CCES
RESPONSES

Civil Engineer Stormwater Best Management Practice (permanent) Certification Letter

RE: **Flying Horse North Filing No. 1**

DETENTION FACILITY NO. 8
SCALE: 1" = 30'

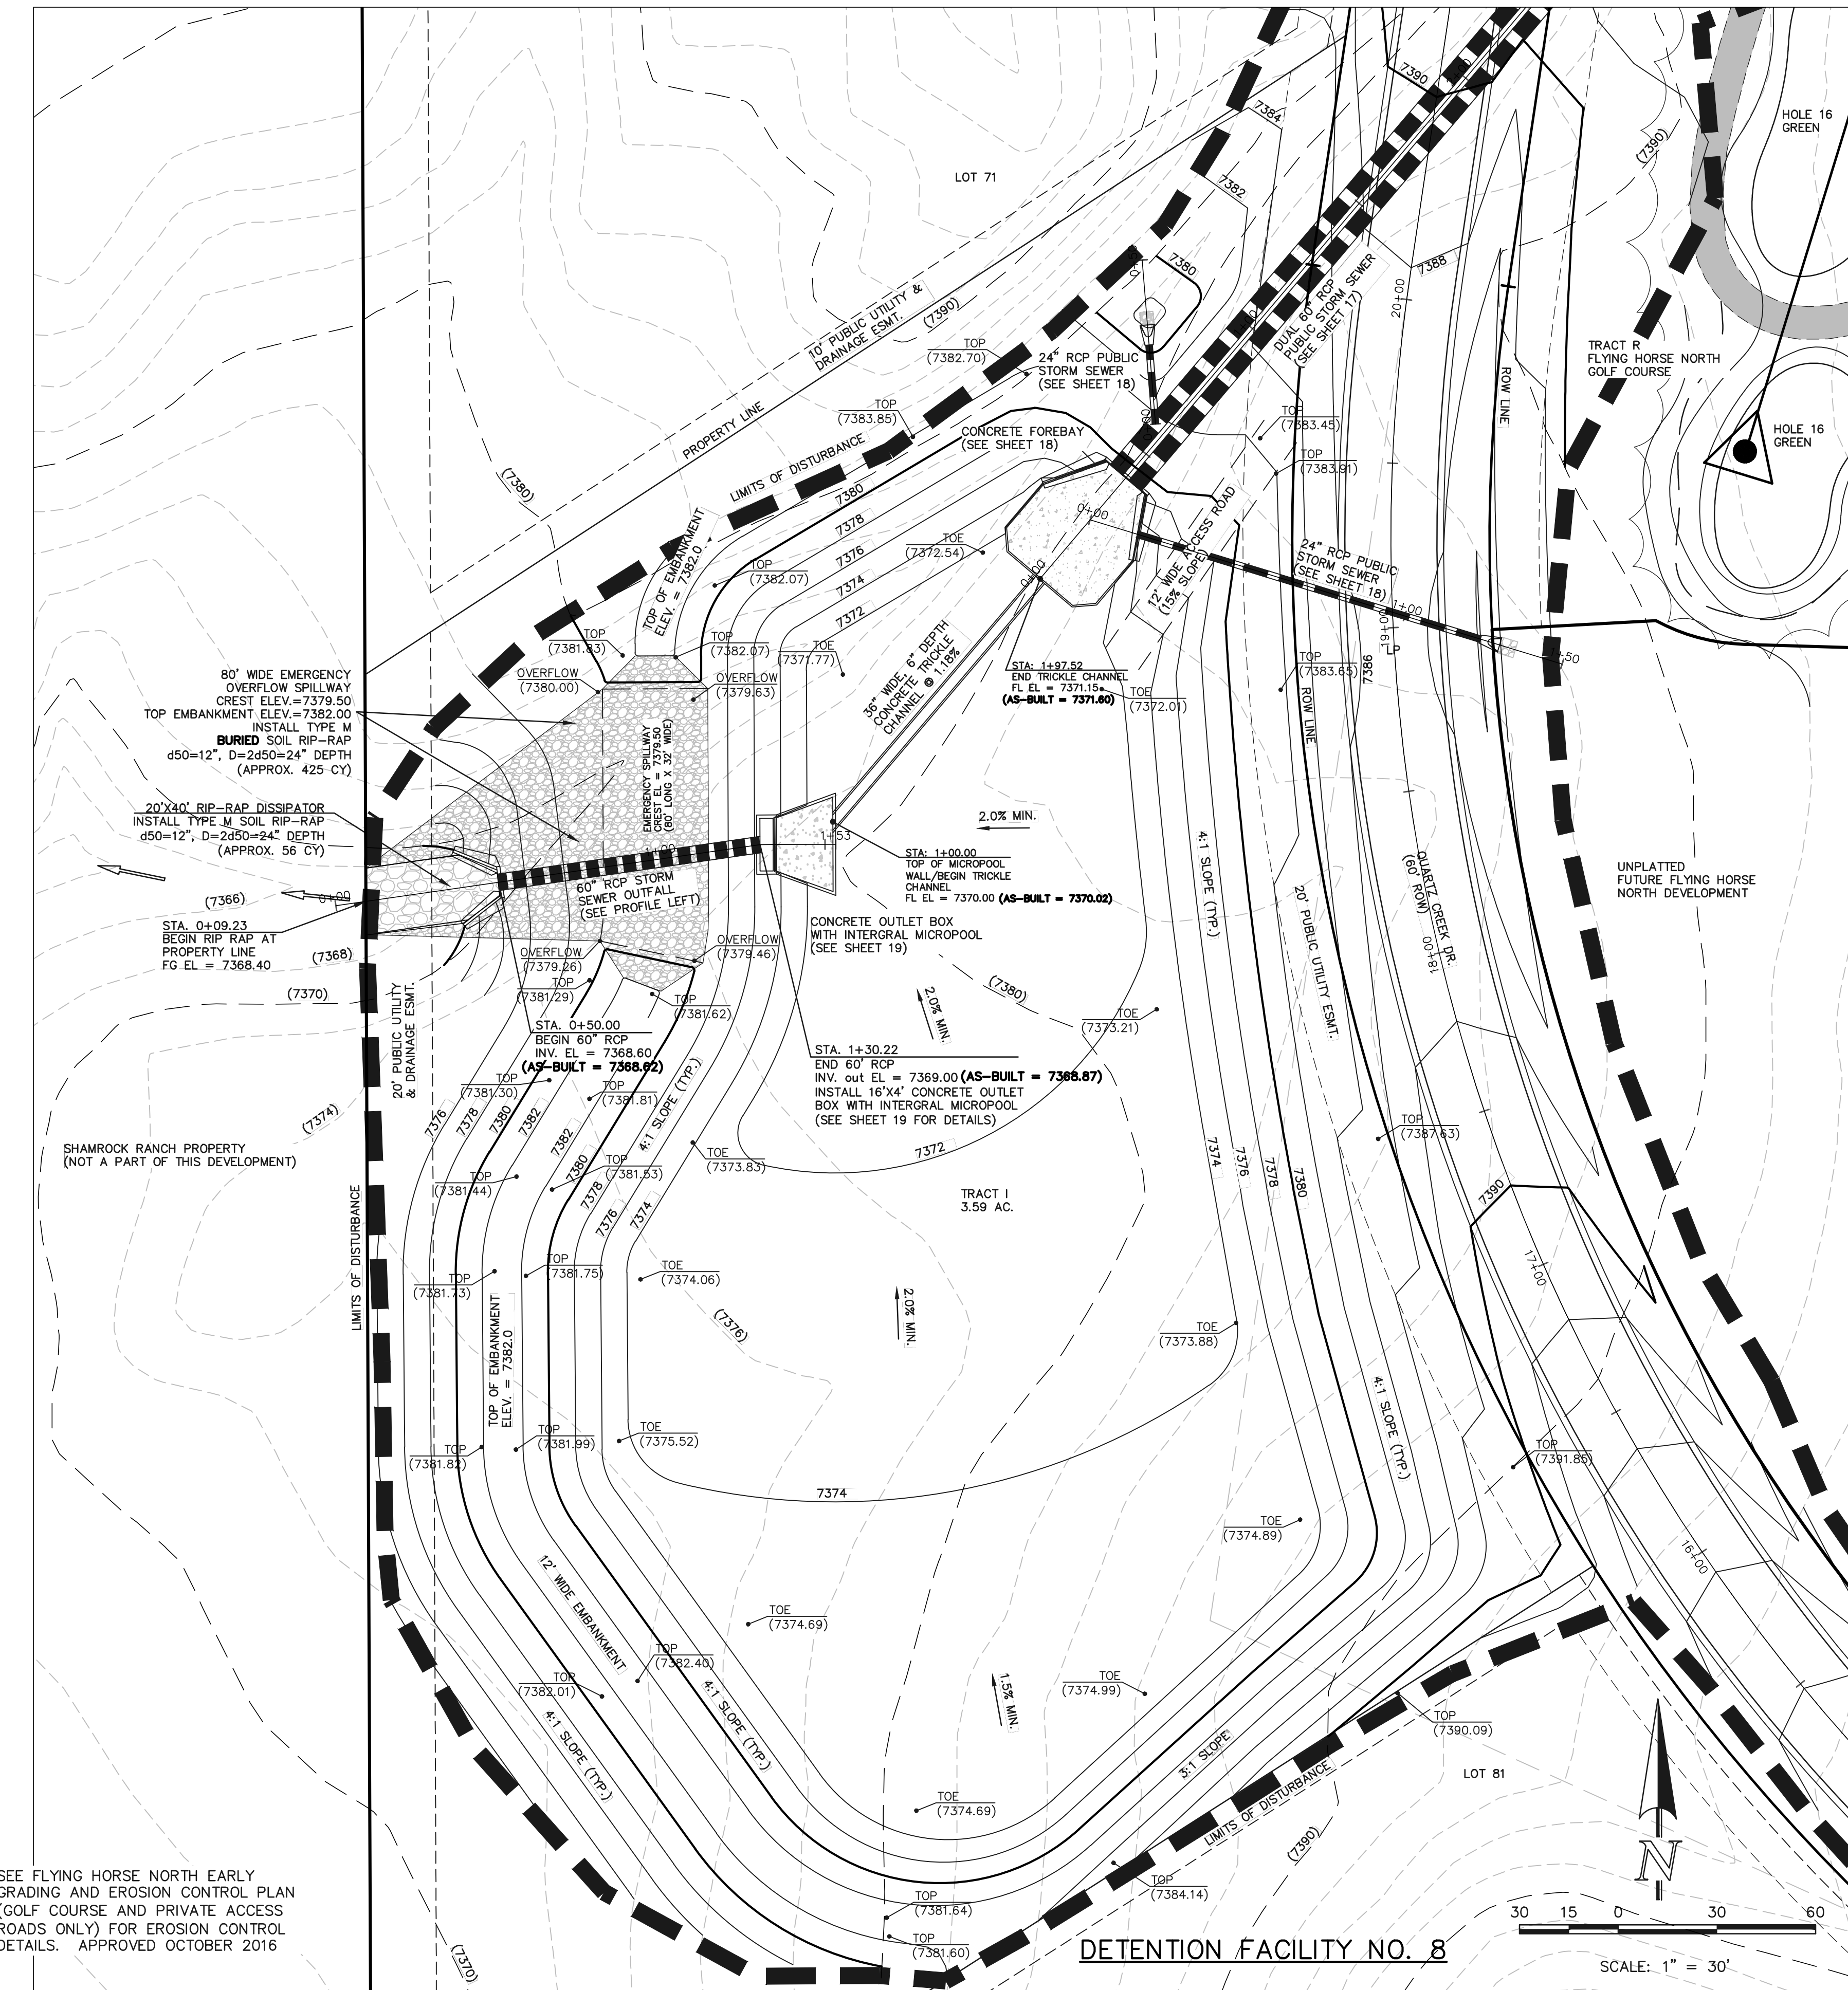
Specifically to forebays: most of the forebays for each pond have significant enough changes from design to as-built condition. So please confirm with calcs that forebay volume is not less than the required volume shown on the UD-BMP spreadsheets submitted with the original FDR. Because for most forebays no extra capacity was provided as a buffer (although some show at most 0.001 ac-ft extra volume, which might be enough).

ADDED ADDITIONAL AS-BUILT INFO. RELATED TO VOLUME OF EACH FOREBAY ALONG WITH VOLUME DESIGN INFO. FROM FDR.
